DELEGATED DECISION TO DETERMINE PLANNING APPLICATIONS

Reference No:	2024/62/93503/W
Site Address:	New Hagg Barn, Oldfield Road, Honley, Holmfirth, HD9 6RN
Description:	Installation of an air source heat pump, enlargement of existing window, new external timber decking and conservation roof lights and associated works (Listed Building)
Recommending Officer:	Joanna Rednall

DECISION – Full Conditional Permission

Drawing Title
**EXISTING &
PROPOSED
ELEVATIONS**

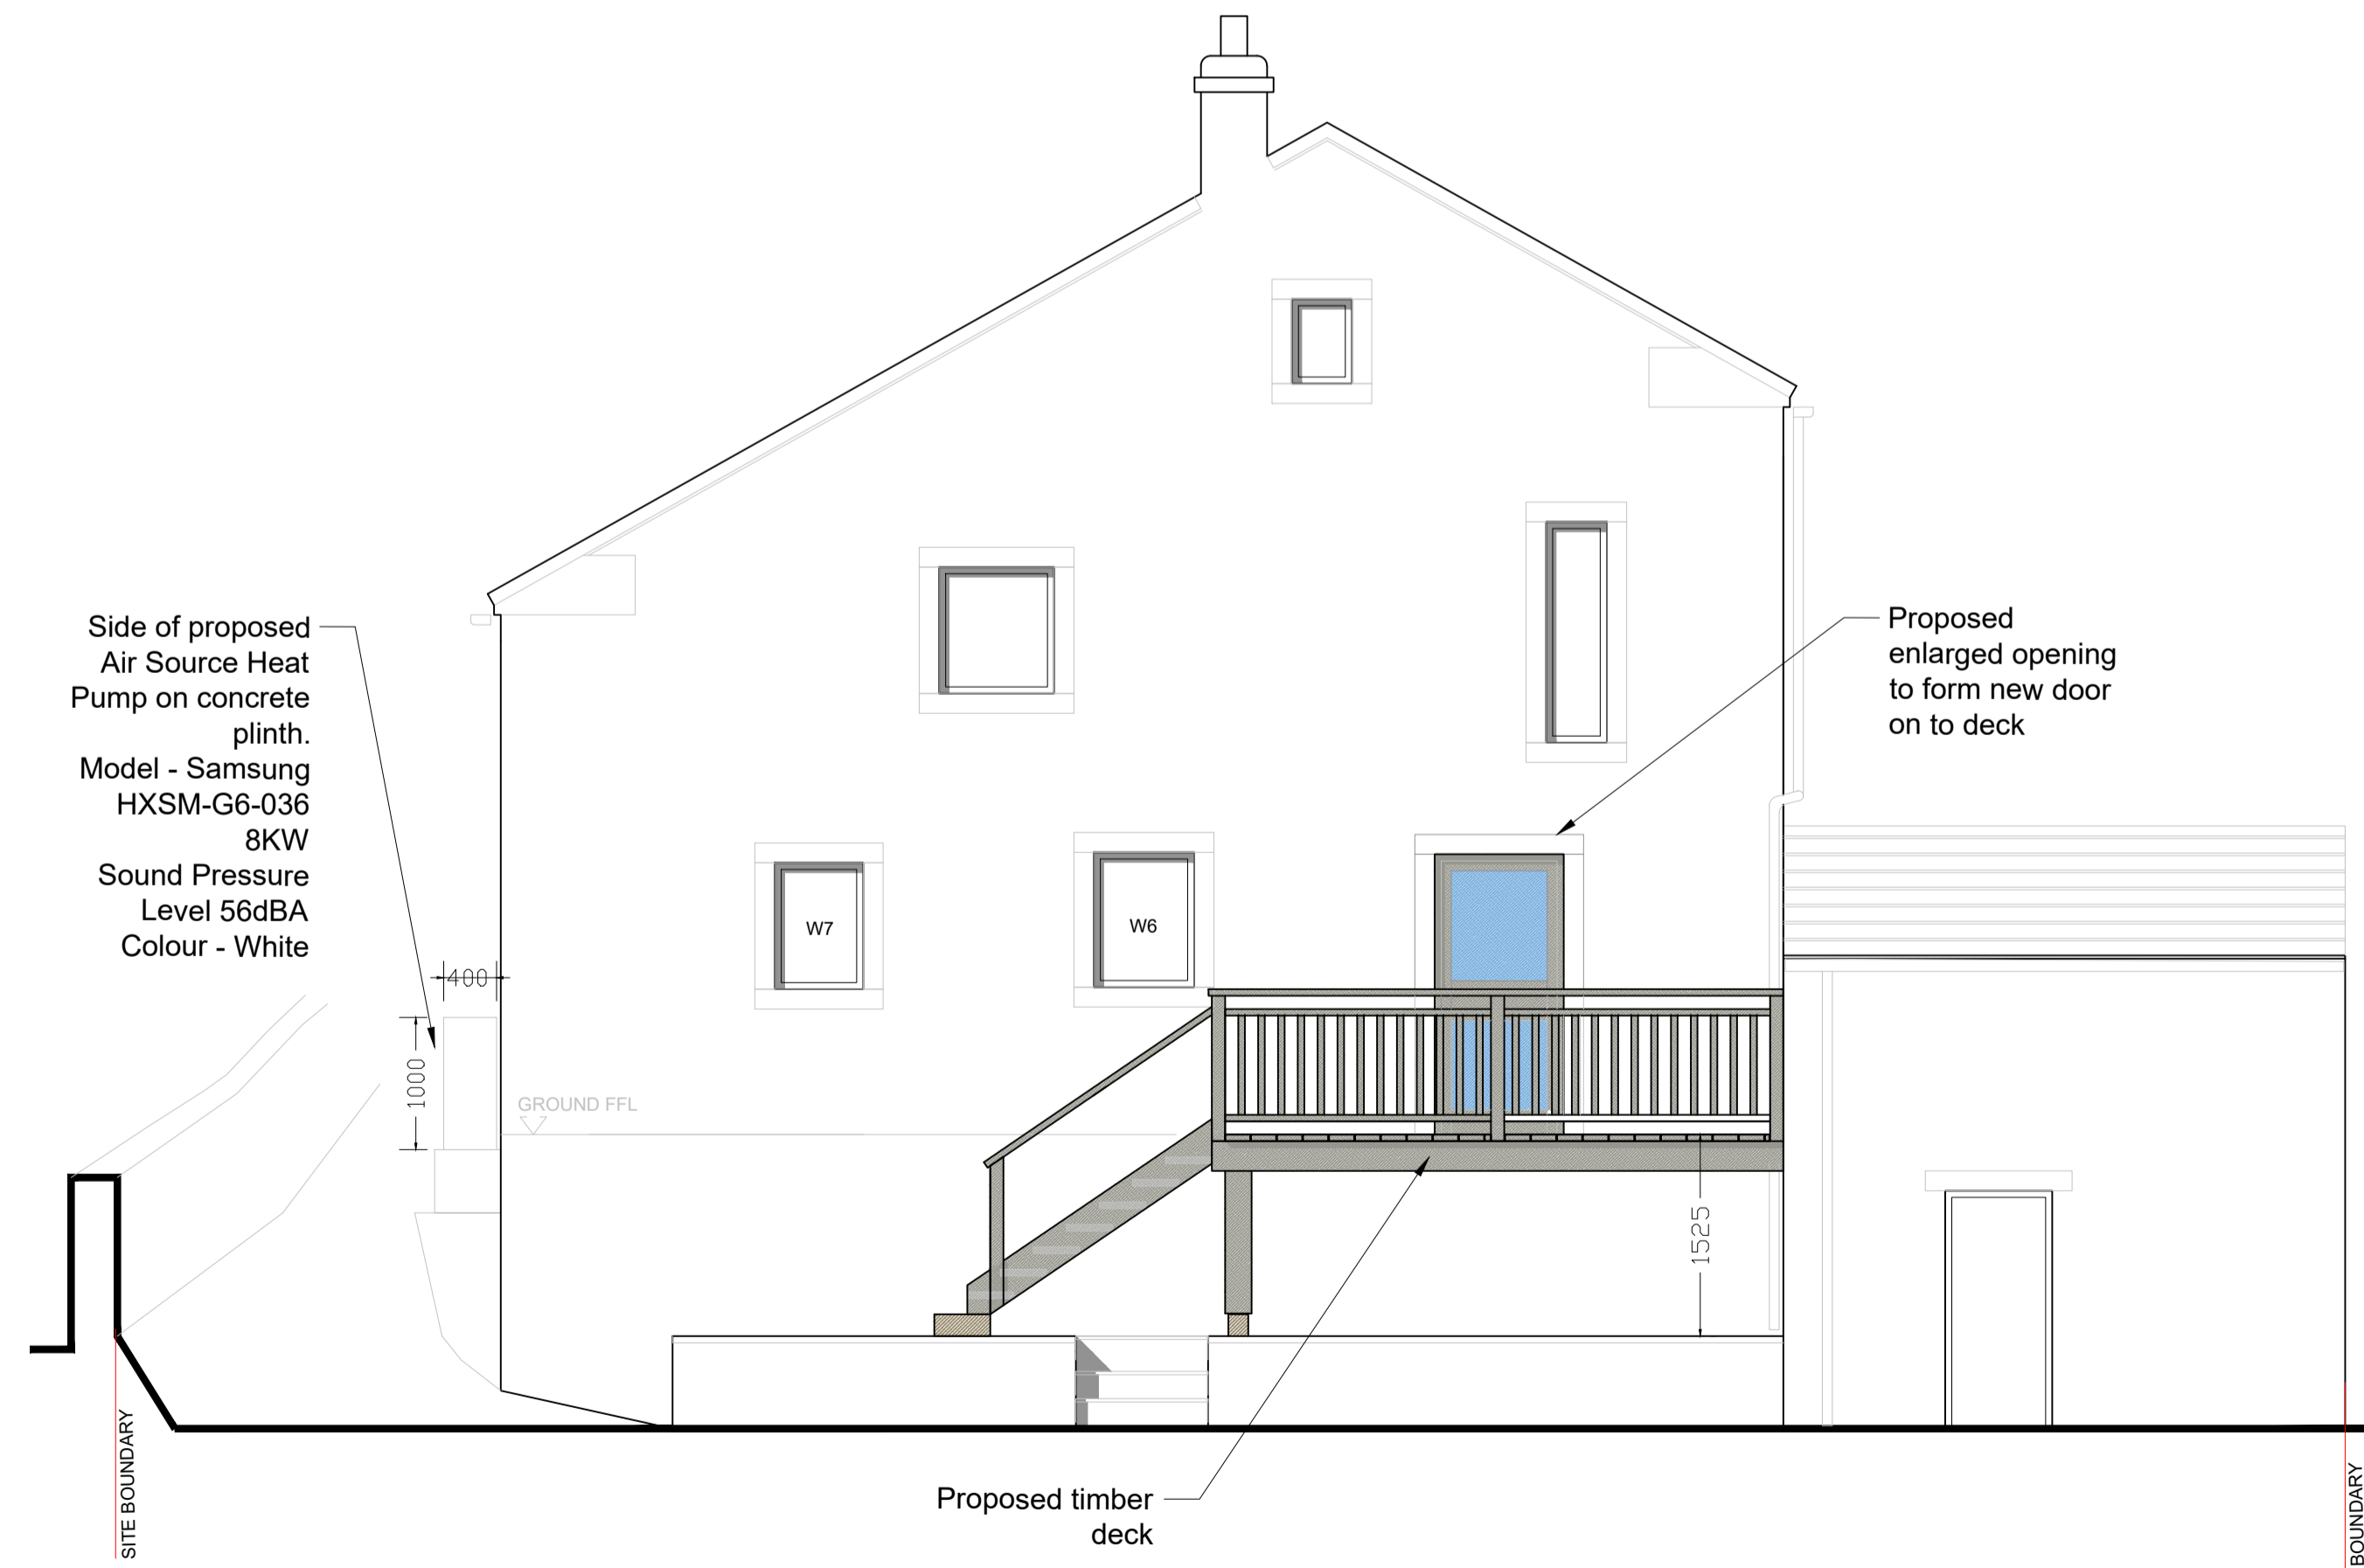
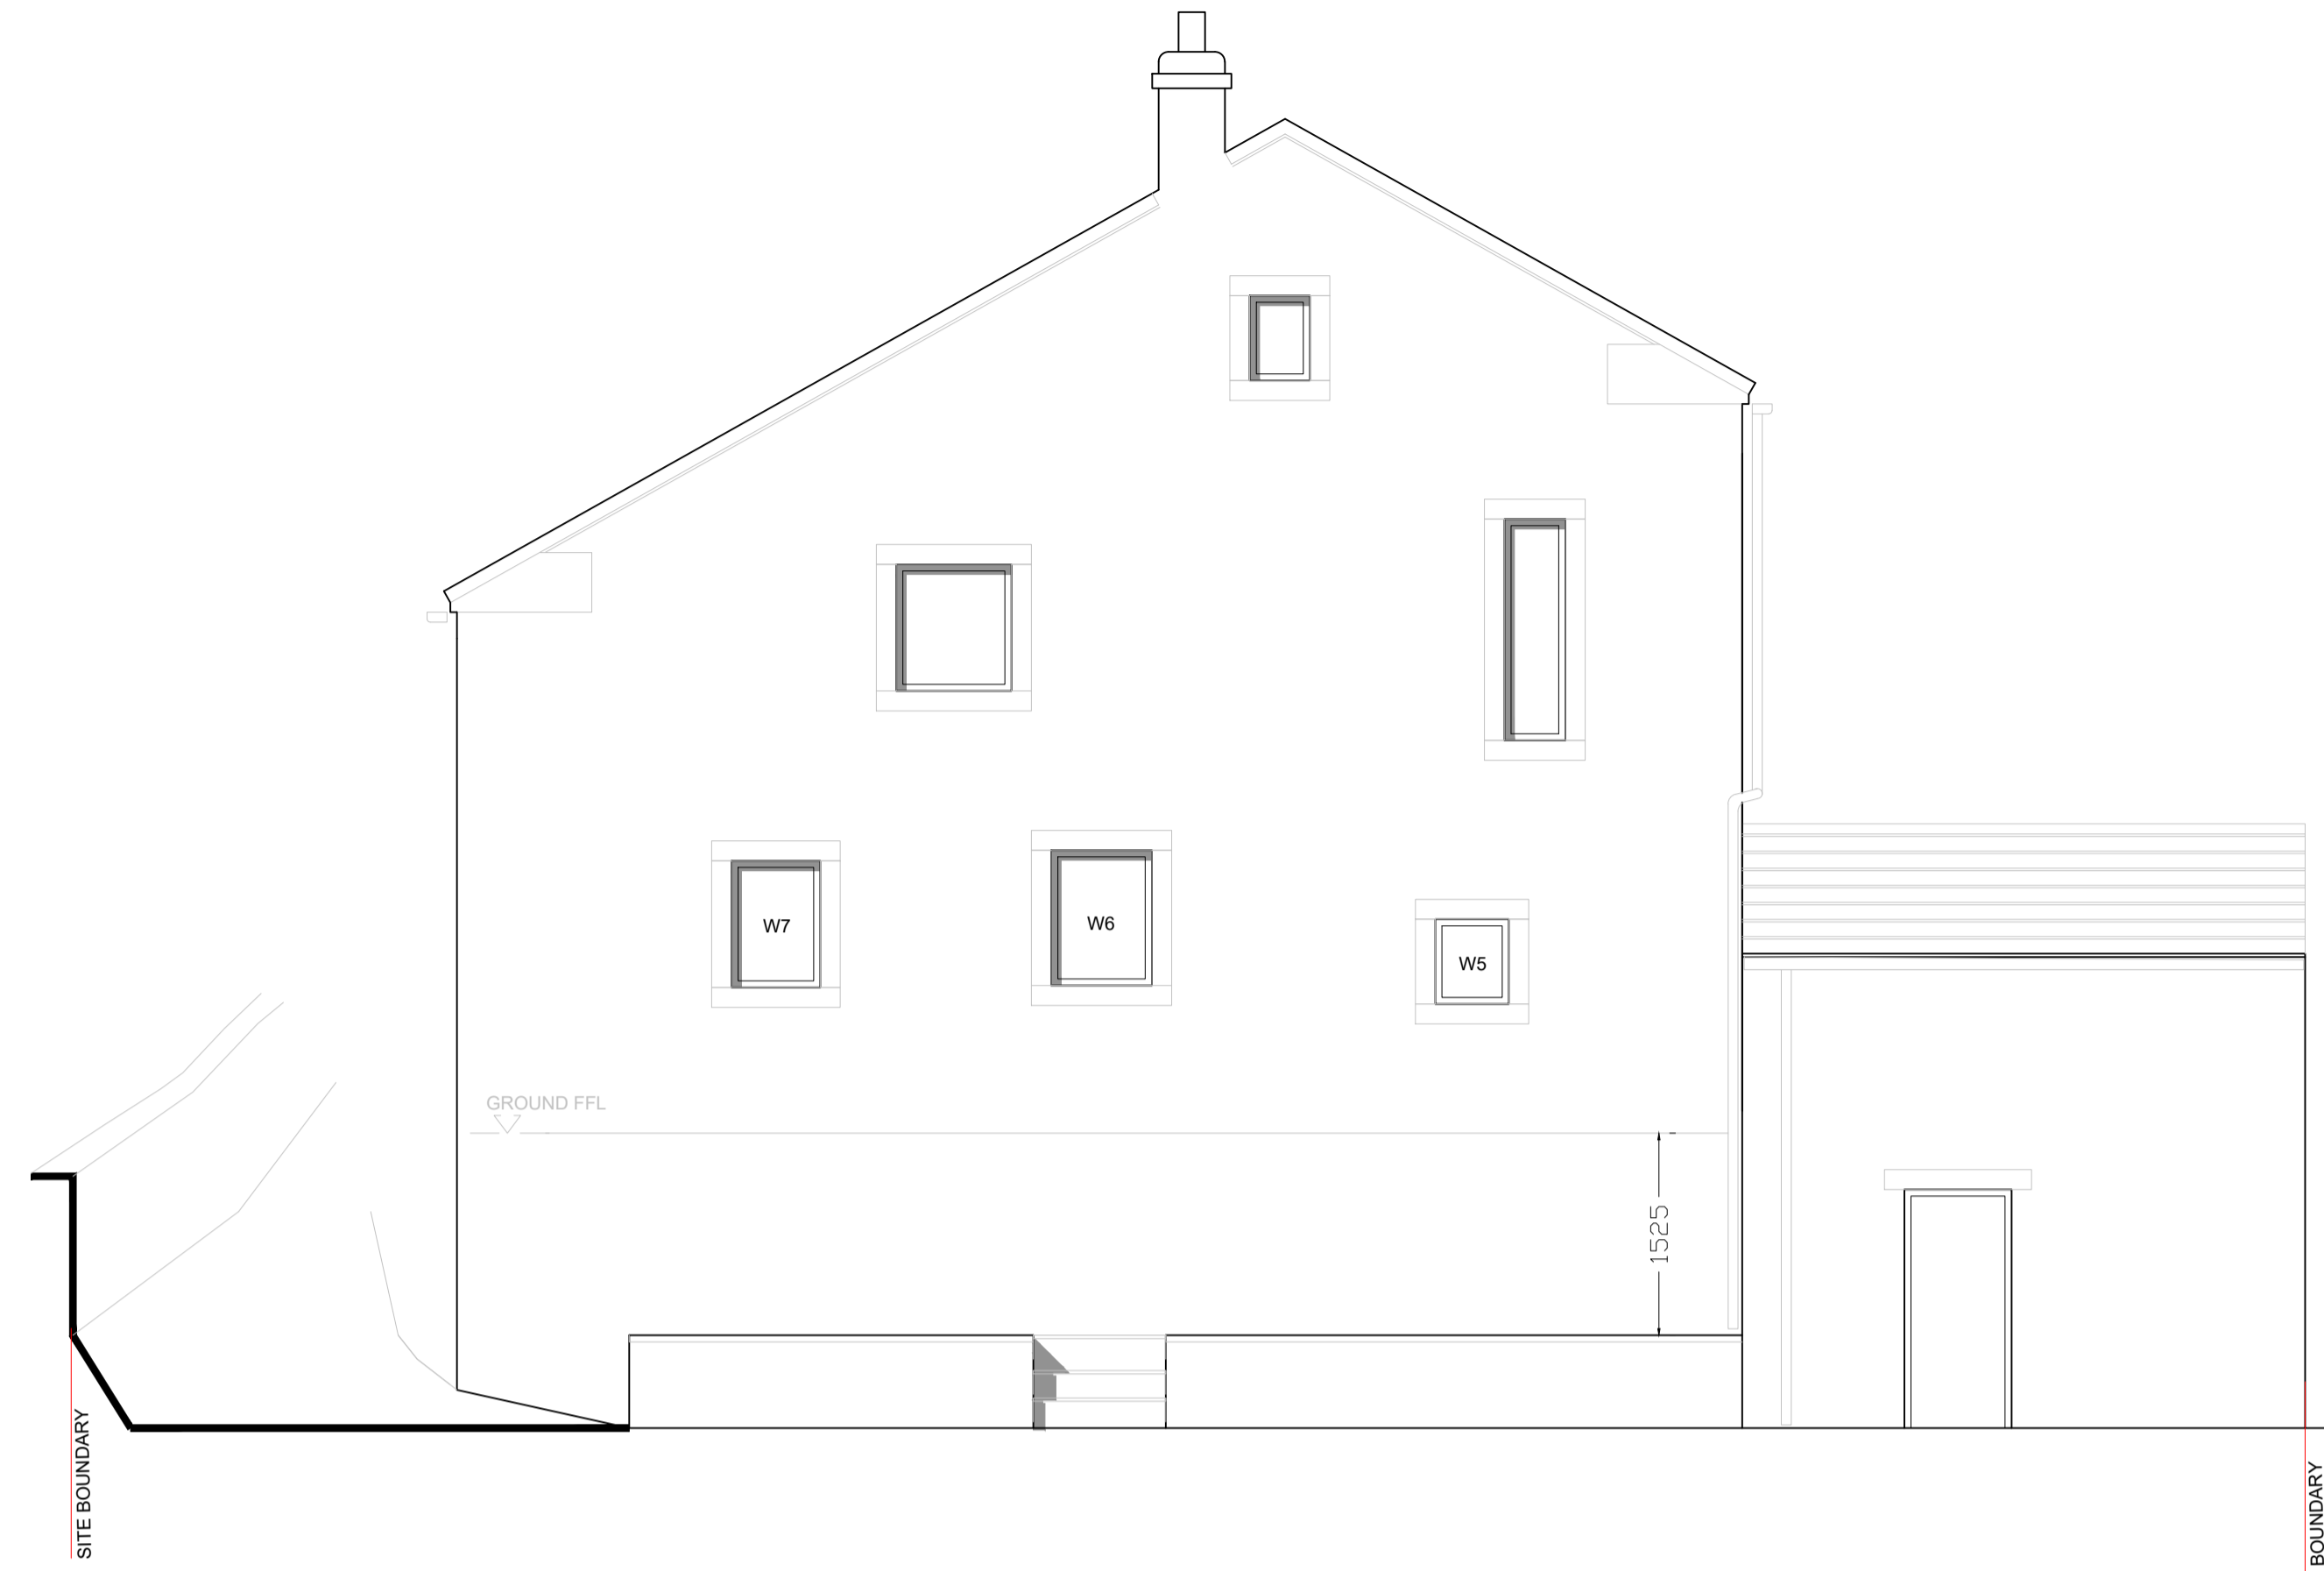
KC Conservation and Design: There is no objection to the proposed air source heat pump or rooflights. However, officers raised concerns regarding the extent of the originally proposed decking, as it would have introduced excessive residential paraphernalia that was inconsistent with the character of the former barn and would have detracted from its historic interest. The extent of decking has since been reduced, and officers consider the revised plans to be more acceptable.

Amendments were sought to reduce the scale of the raised decking in response to the comments from the Council's Conservation and Design Officer. Amended plans were received 28th March 2025 which were deemed acceptable and the application has progressed on this basis. The amended plans were not re-publicised as these did not fundamentally change the development applied for.
